Briefing Note

Our ref 64194/06/MS/OW
Date 17 October 2025
To Planning Inspectorate
From Oxford Aviation Services Limited

Subject Deadline D6 – Summary of Oral Evidence

Figure 5 - Illustrative Masterplan

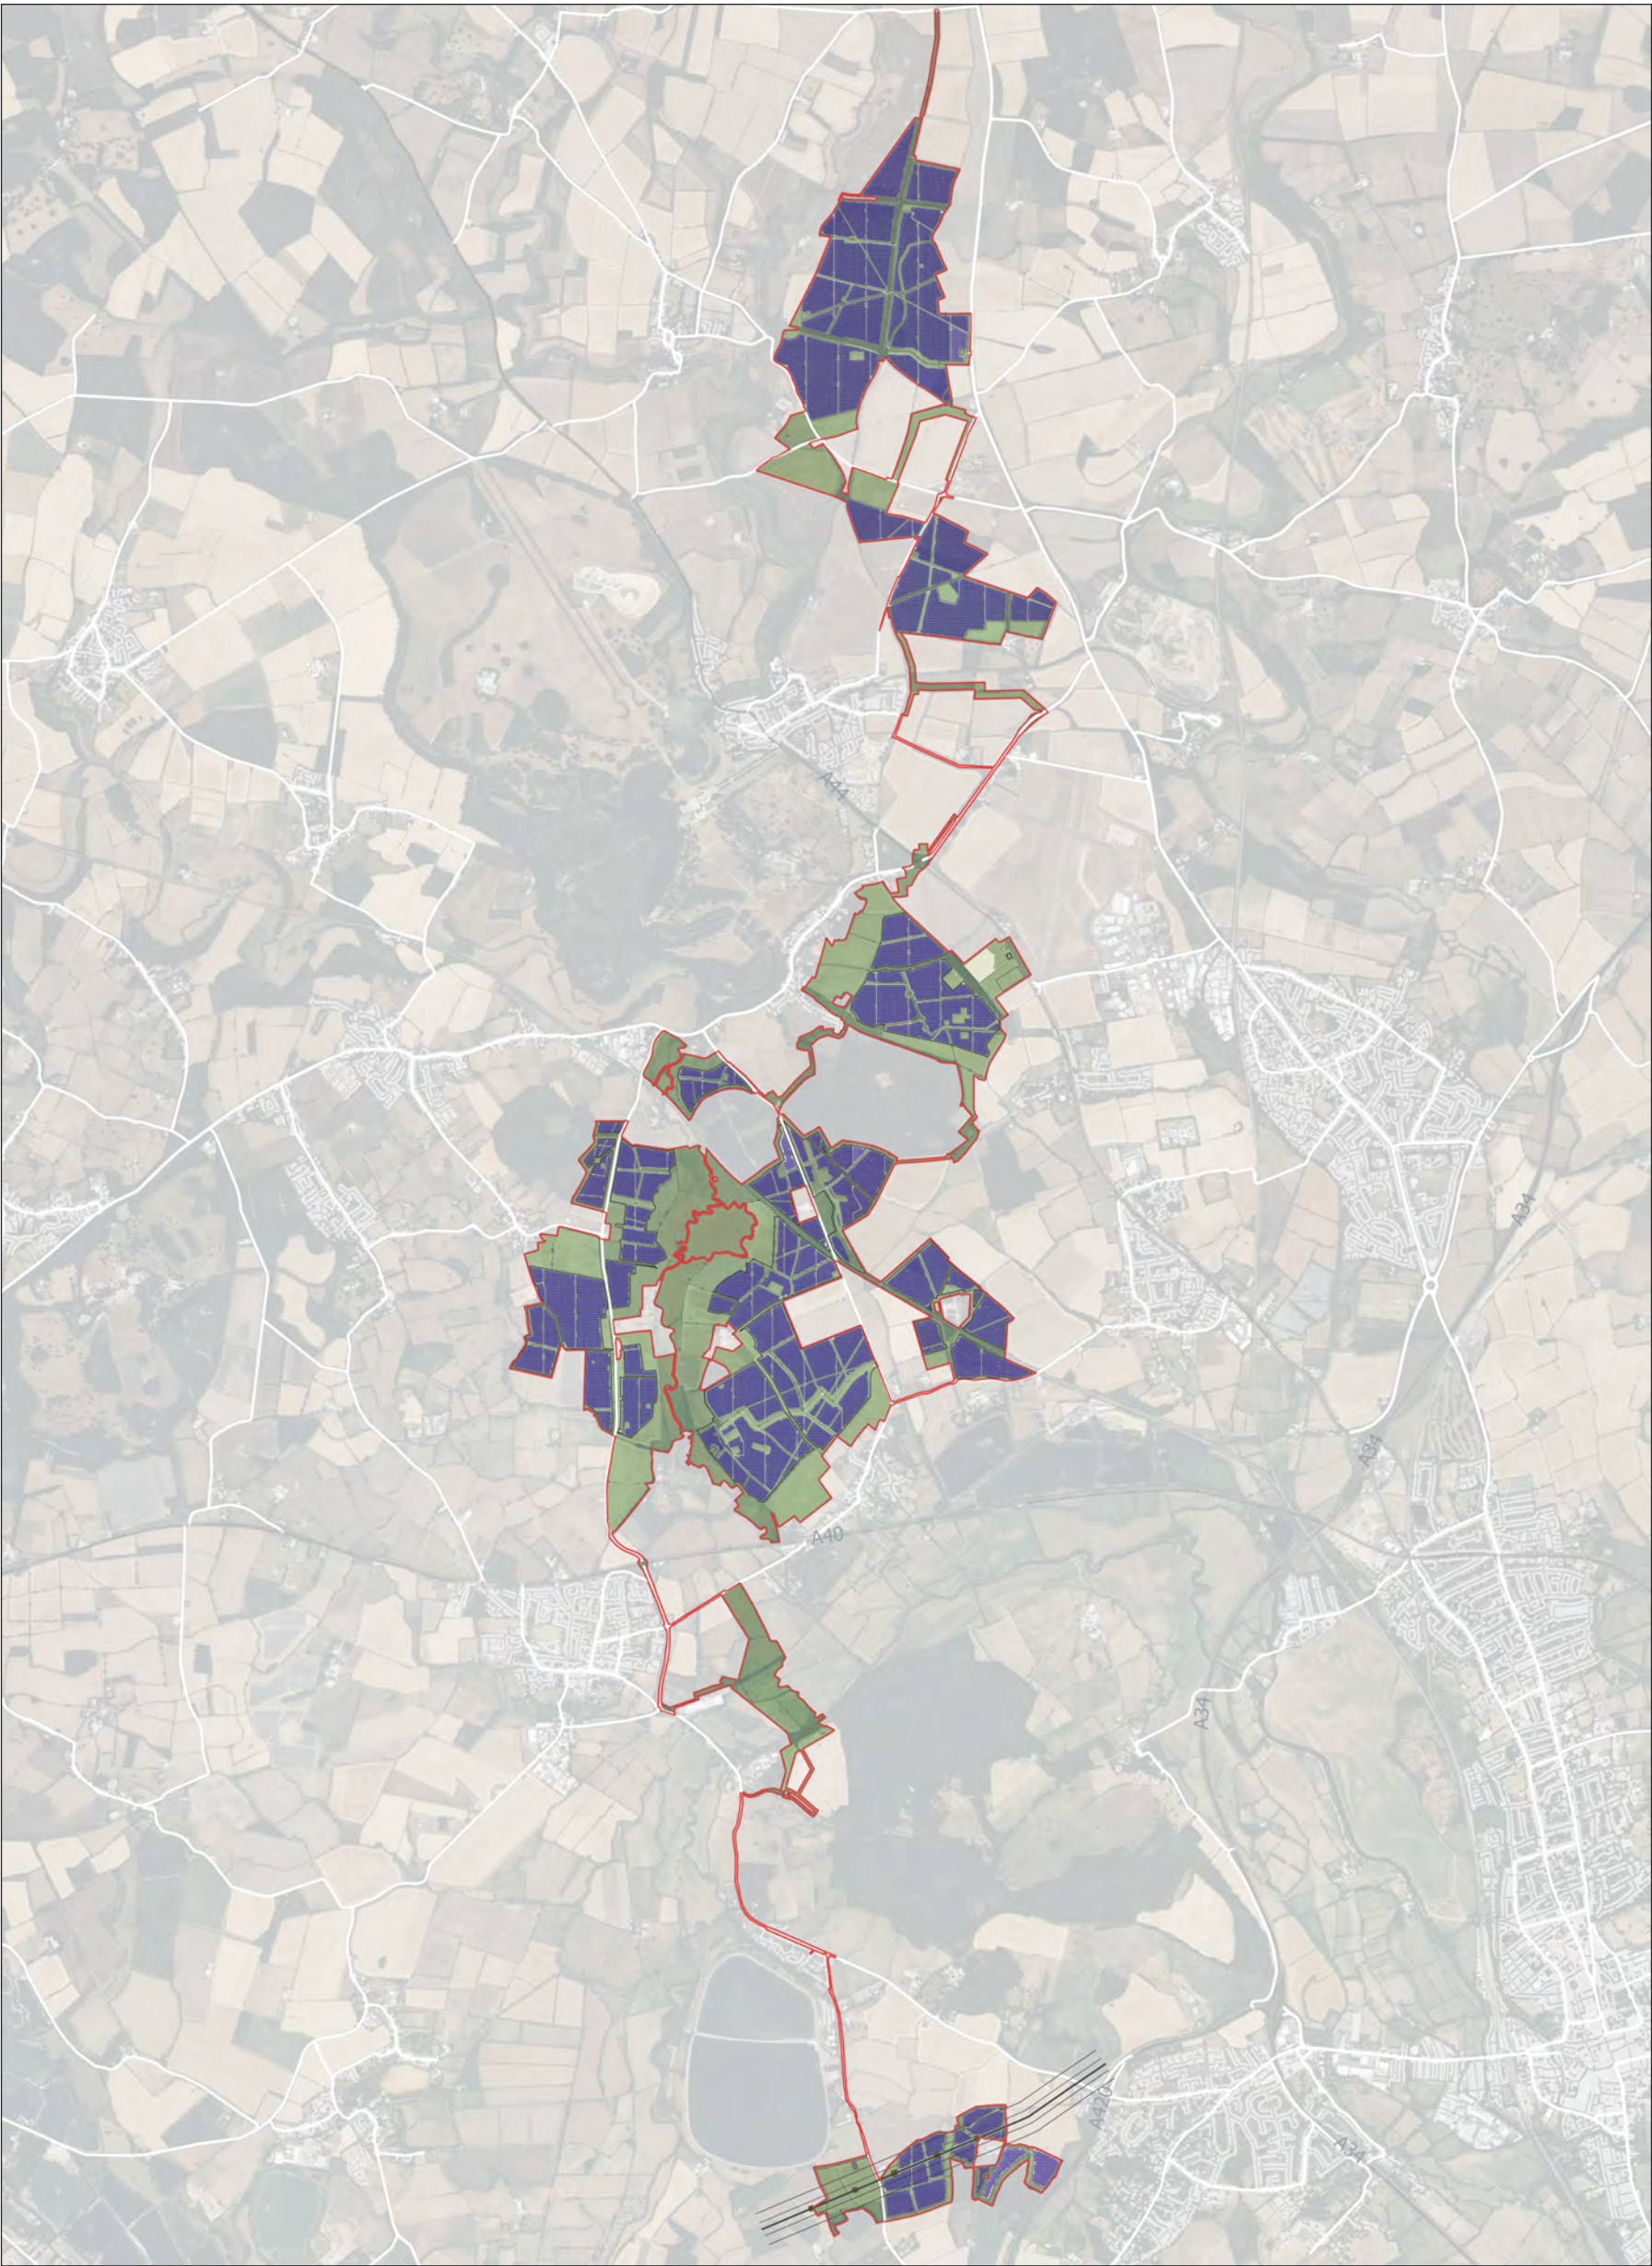
- 3.1 Whilst not discussed at the hearing, due to time pressures, OASL note that Rev 7 of the draft DCO (CR2-009), is not up to date. In particular, we note that in Schedule 13 Part 2 ‘Figures 2.1a - 2.4c - Illustrative Masterplan’ are still ‘January 2025’ versions. The referenced plans should be updated, as they do not reflect the latest extent of the proposed Order. There are concerns that there may be further updates required and therefore OASL wish to request that the references in the draft consent order are checked thoroughly.
